7 February 2012

**Proposed Modification to Approved Major Project No. 09\_0051 – Centre for Obesity, Diabetes & Cardiovascular Disease**

I refer to our recent discussions and the response to the City of Sydney package delivered to the Department on the 27 January 2011. The response package included architectural documents that illustrated changes and refinements to the scheme via perspectives and elevations as well as explanatory diagrams such as building alignments and ground plane elements.

Building Alignments

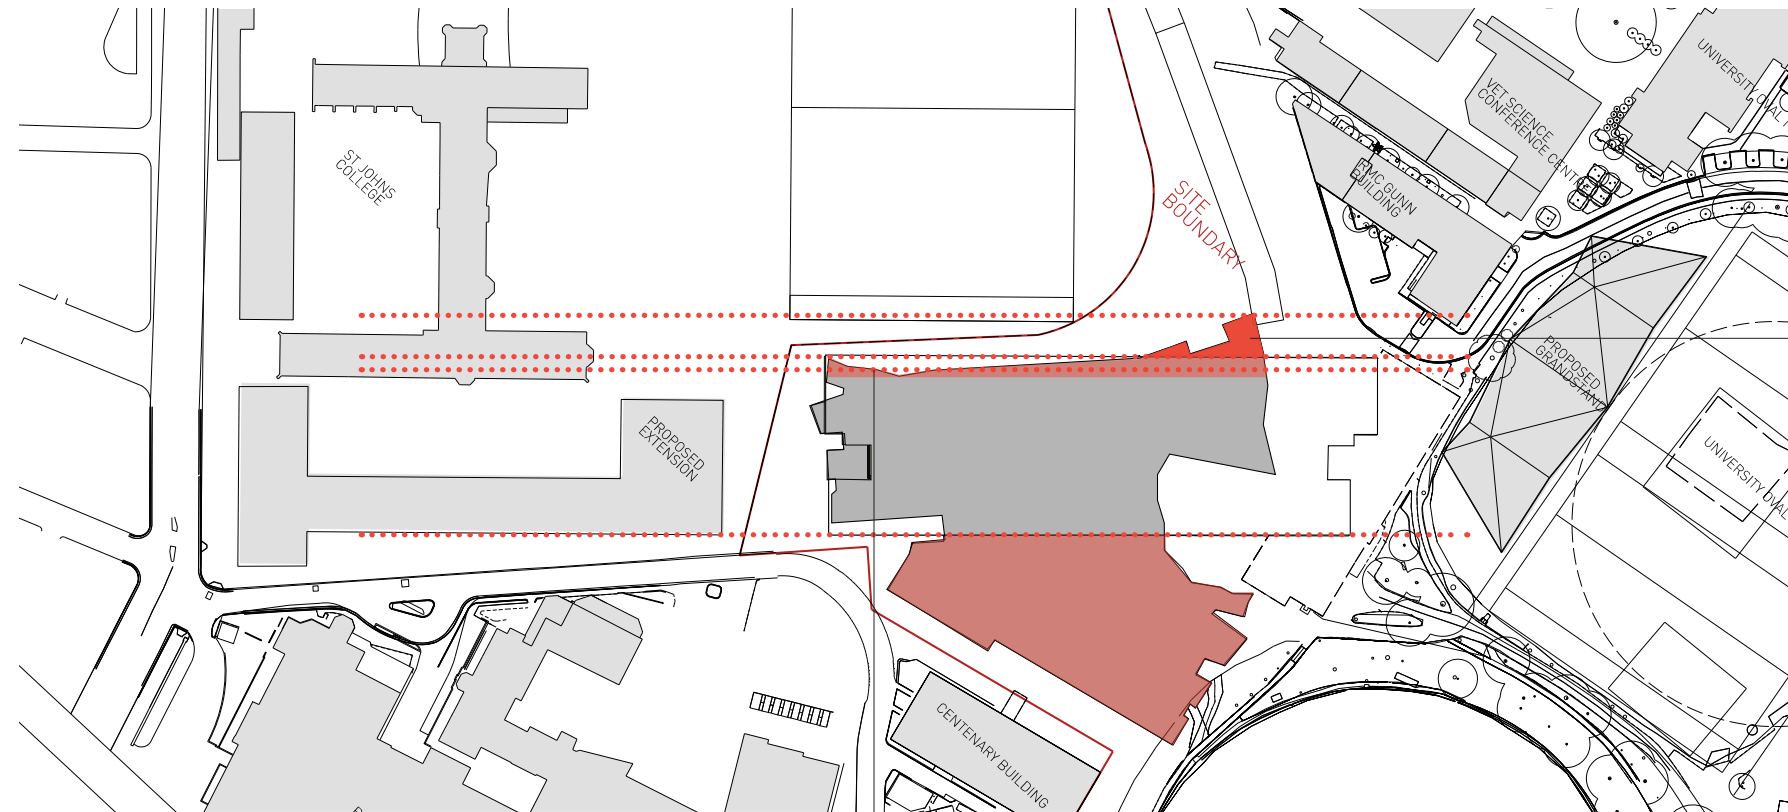
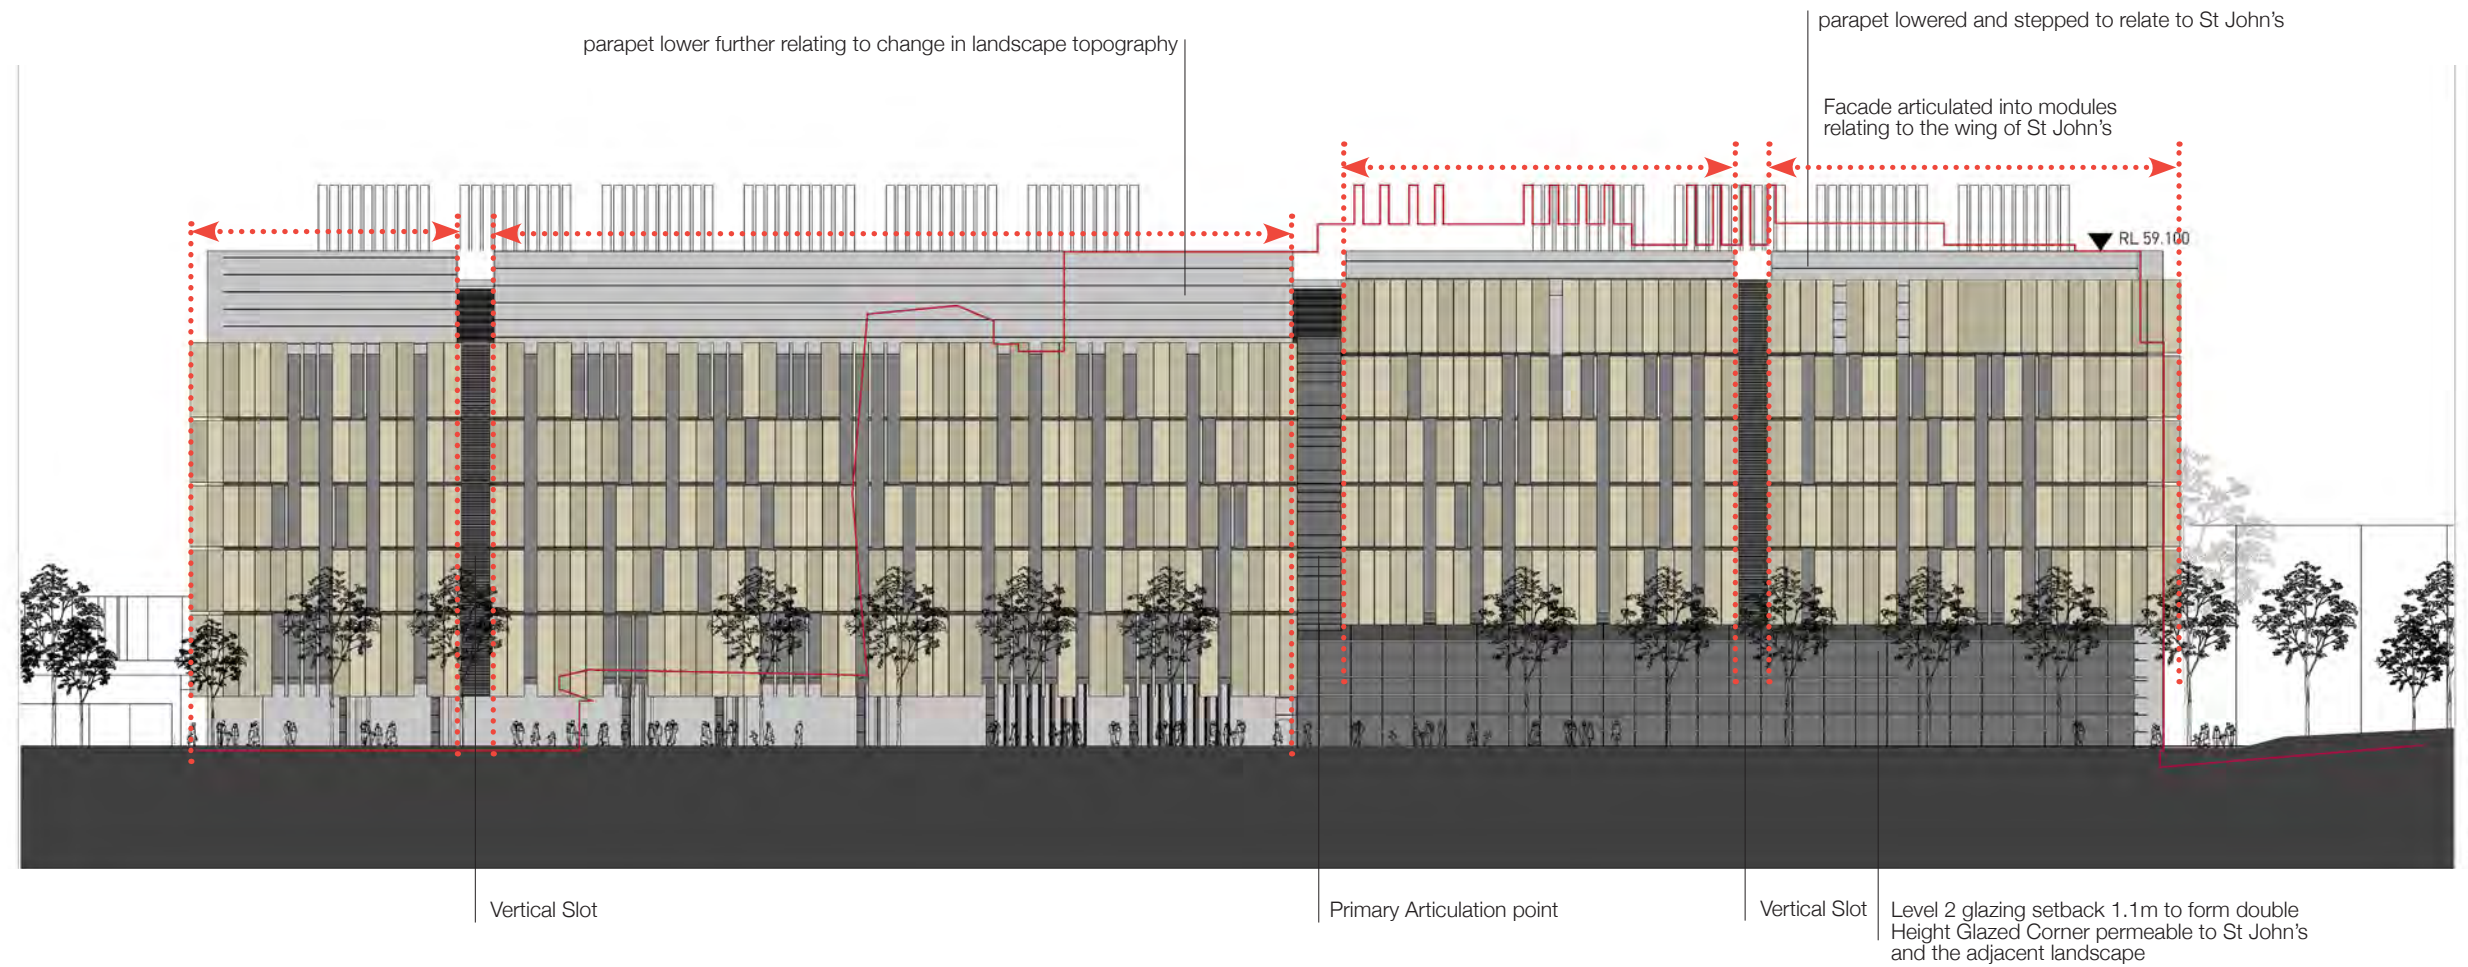
- The proposed northern alignment is sited south of the approved scheme's floor plate, where it projects into the north-east view corridor as illustrated in the diagram below. The proposed northern alignment is 11.8m south of the north – eastern corner of the approved scheme from Level 2 to roof level. Proposed Level 1 is also setback a further 1.1m south in this location.

- The proposed north-western corner area of Level 1 is approximately 900mm south of the approved north-western corner.
  - Level 2 has been amended from the submitted scheme to include a setback of 1.1m in the north-western corner along the northern façade to follow the alignment of Level 1 below. This contributes towards opening up the view corridor to the north-east at the ground plane, in conjunction with the inclusion of glazing to Level 2.

- The upper levels, up to the parapet in the north-western corner and along the northern face of the proposed building are aligned with the centre line of the St John's College Southern Annex. In conjunction with the significant setback of the proposed north – eastern corner relative to the approved scheme, from Level 1 to roof level, the result is a positive gain. As illustrated in the diagram below, it is evident that the views to and from St John's College in the north-east primary view corridor is widened in comparison to the approved scheme.
